Progress Garage, Yapton Lane, Walberton BN18 0AS – Application for the variation of a condition following grant of planning permission LA Ref: WA/29/17/RES

On behalf of our client we submit an application in relation to the above site to vary condition 2 attached to planning permission LA Ref: WA/29/17/RES (granted on 17th July 2017) for minor alterations to the siting of plots 5 & 6 – relocating the pair of houses 600mm to the east.

0912/DPA109

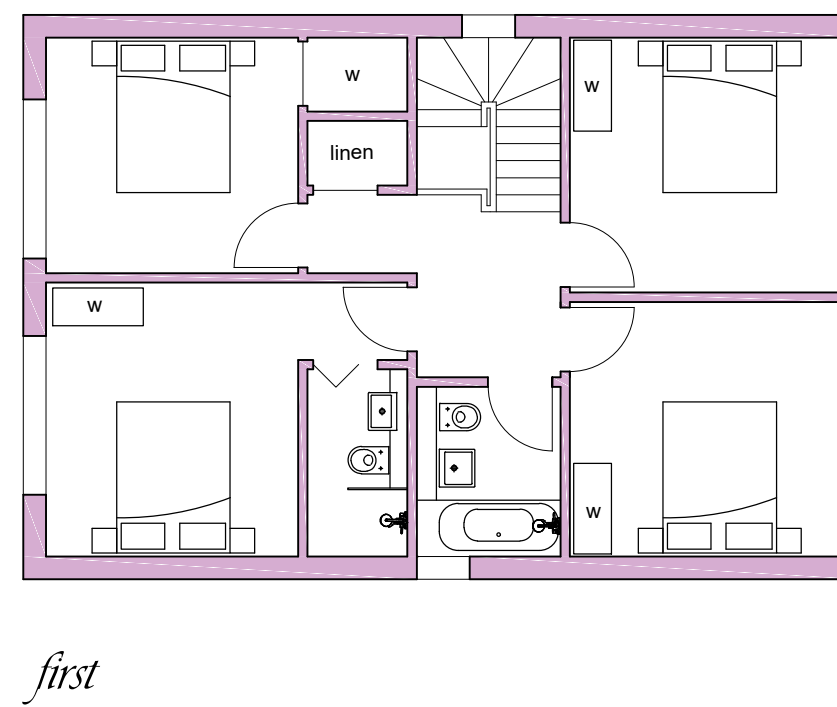
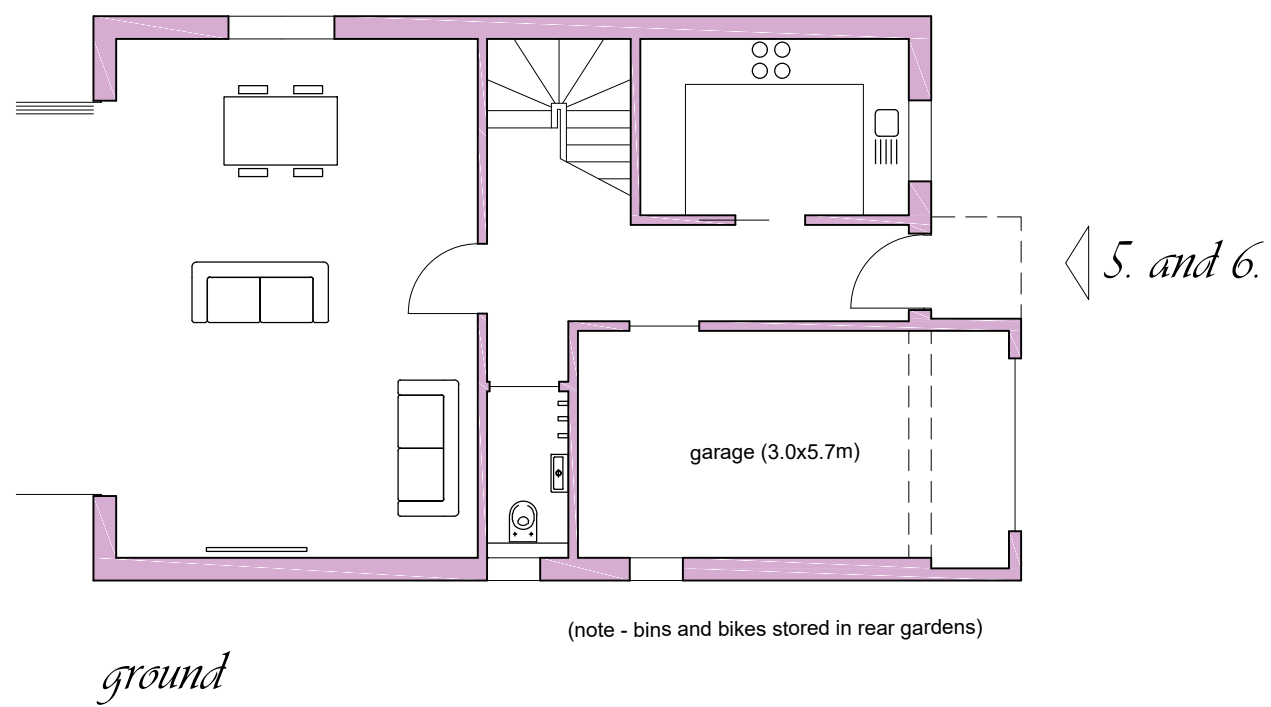
The application comprises the amended plans, 0912/DPA102 Rev 03, 0912/DPA103 Rev 03, 0912/DPA104 Rev 03, 0912/DPA109 Rev 03 and 0912/DPA110 Rev 03 to replace the previously approved plan nos. 0912/DPA102 Rev 02, 0912/DPA103 Rev 02, 0912/DPA104 Rev 02, 0912/DPA109 Rev 02 and 0912/DPA110 Rev 02 referenced under condition 2 attached to planning permission LA Ref: WA/29/17/RES.
